October 7, 2019

RE: **2440 Louisiana NE**
Grading and Drainage Plan
Engineer's Stamp Date: 9/25/19
Hydrology File: H19D084

Based on the submittal received on 9/25/19 the above-referenced Grading and Drainage Plan cannot be approved for Grading or Paving Permit until the following corrections are made:

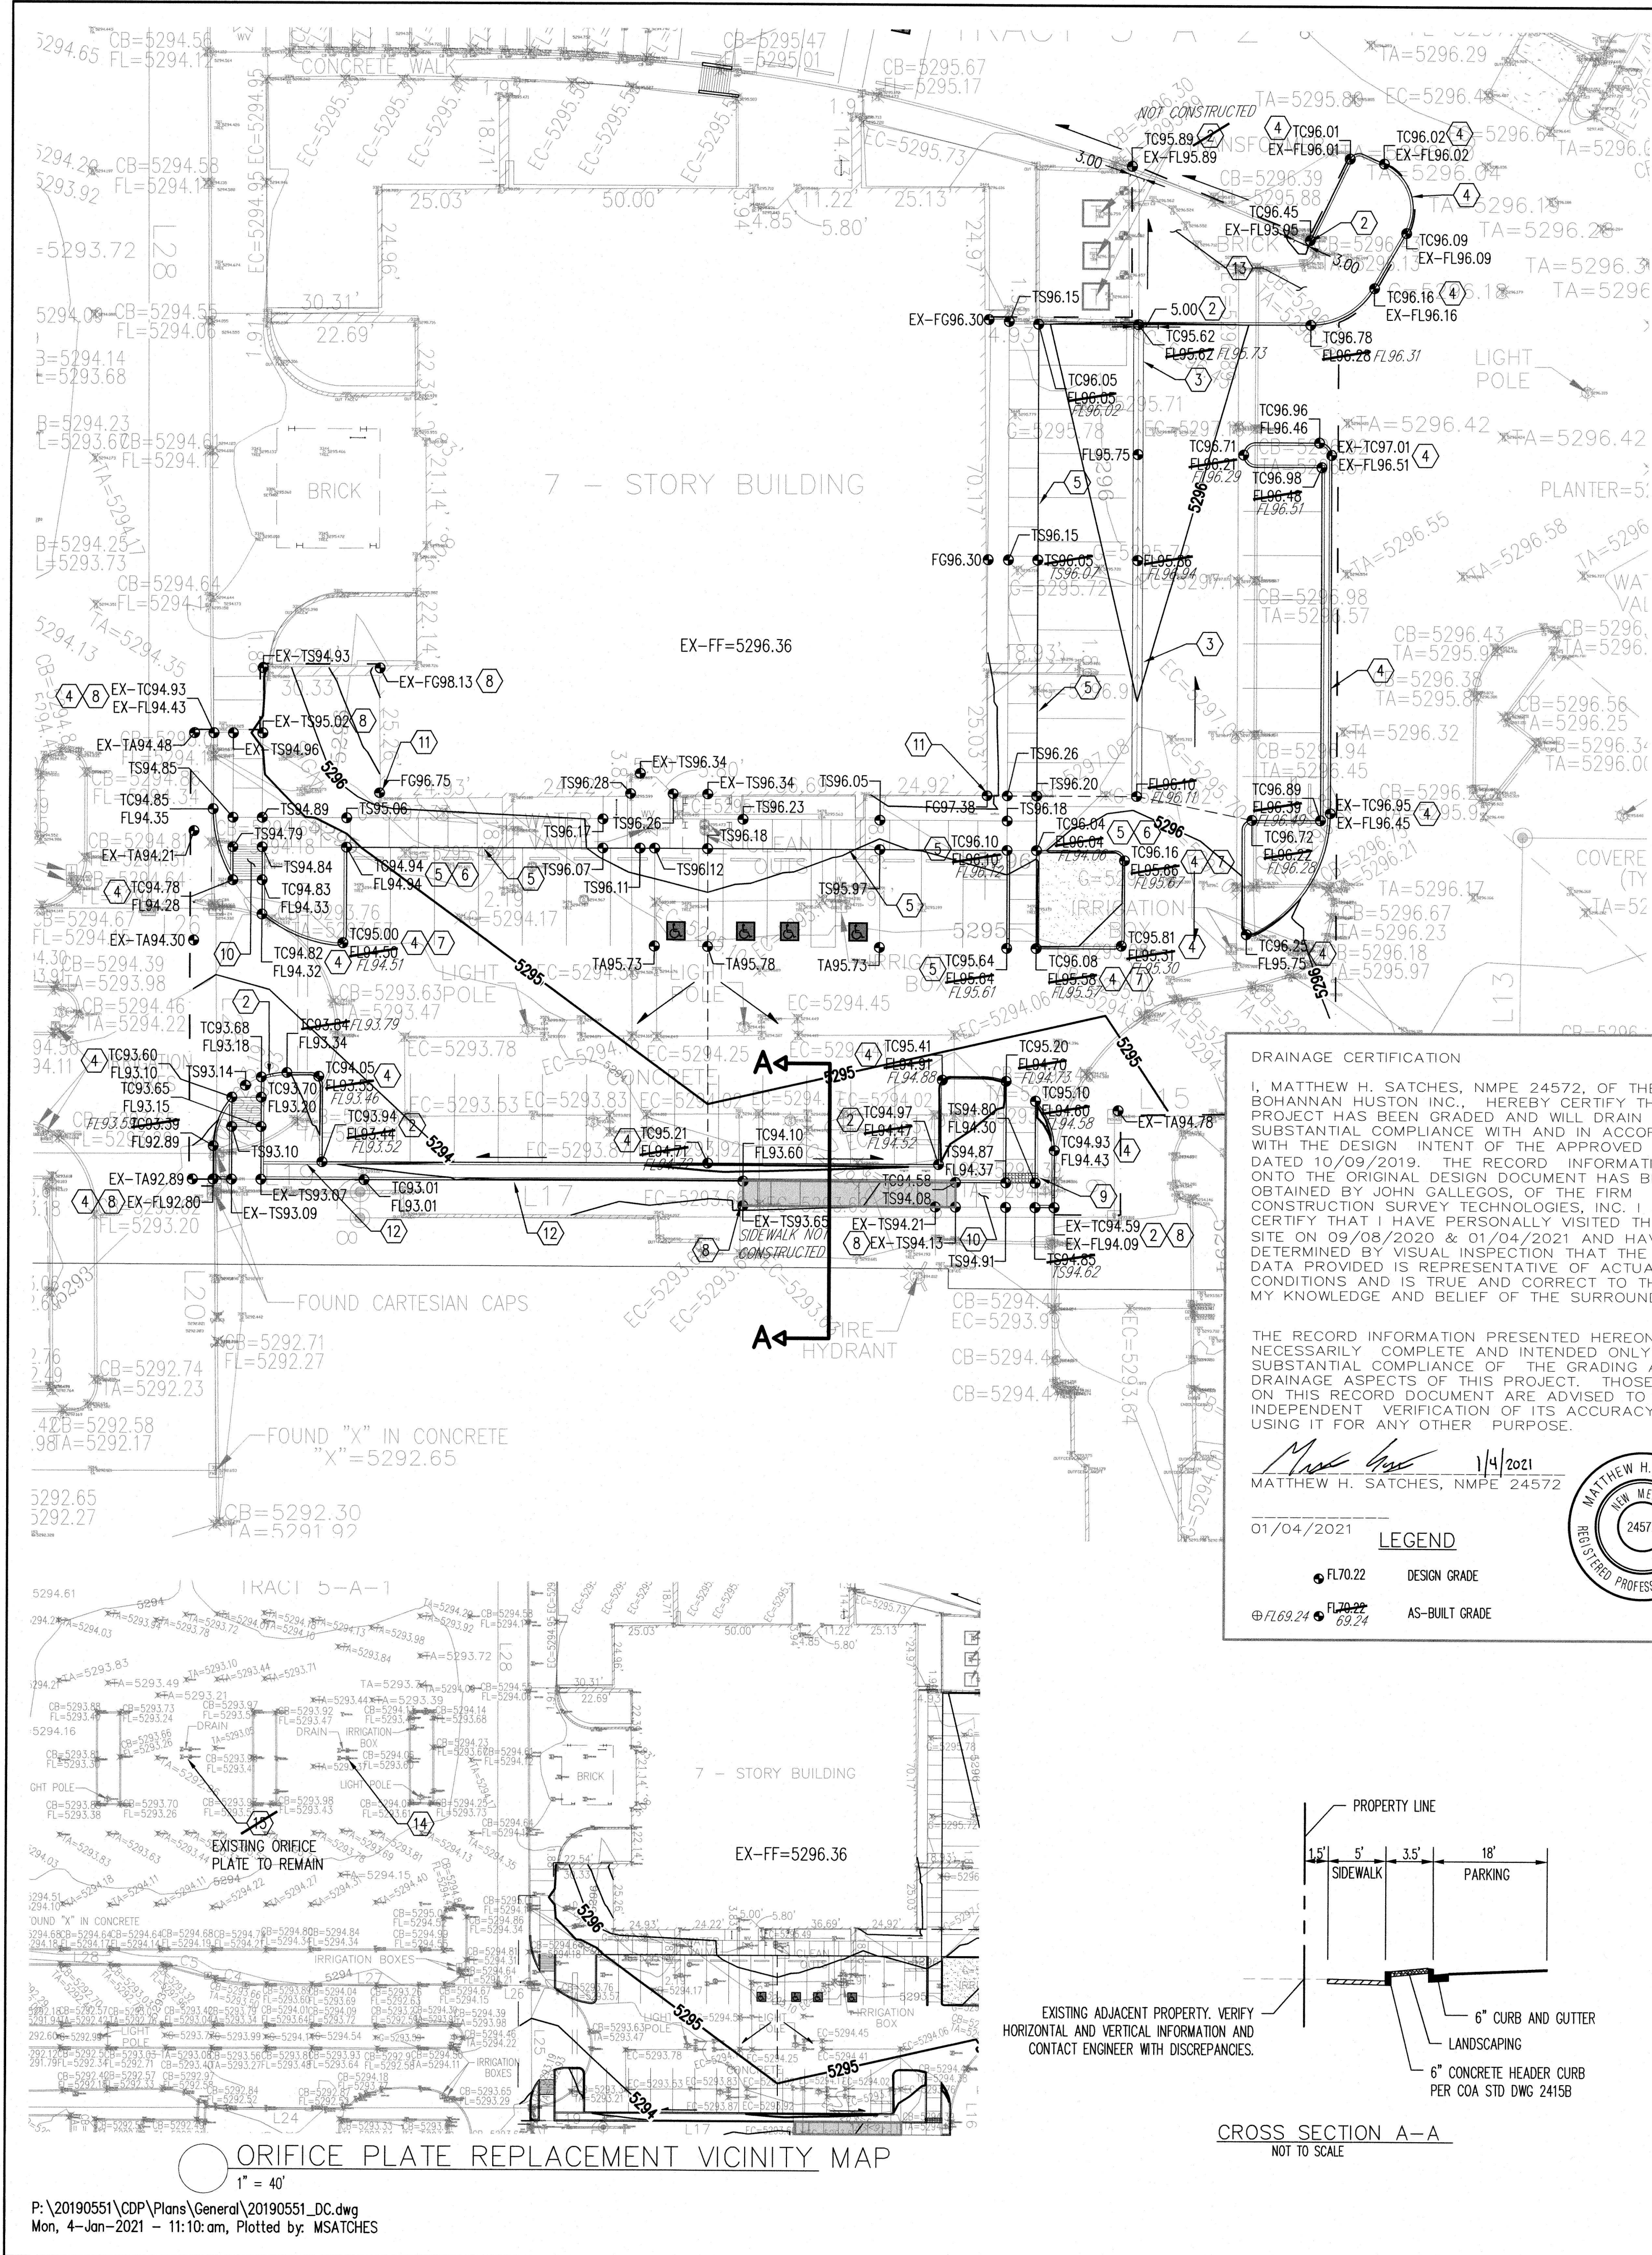
1. The orifice plates on inlets 2 and 3 in the NW parking lot (outfall for proposed basin C) are missing and need to be replaced in order for the parking lot detention pond to function as proposed. Include this repair/replacement work on the plan. The orifice plates for the SW parking lot (outfall for basin B) were recently replaced and the pond near the parking garage entrance is still in place, so those outfalls are acceptable.
2. Payment in Lieu (Amount = $482\text{CF} \times \$8/\text{CF} = \3856 , per sheet C-001) of onsite management of the SWQV must be made. Take three copies of the treasury deposit slip to the Treasury and then include one copy of the paid deposit slip when resubmitting.
3. Because these corrections are minor, the administrative resubmittal fee of \$40 may be used. Please include a copy of this letter when resubmitting in order to receive the reduced fee.
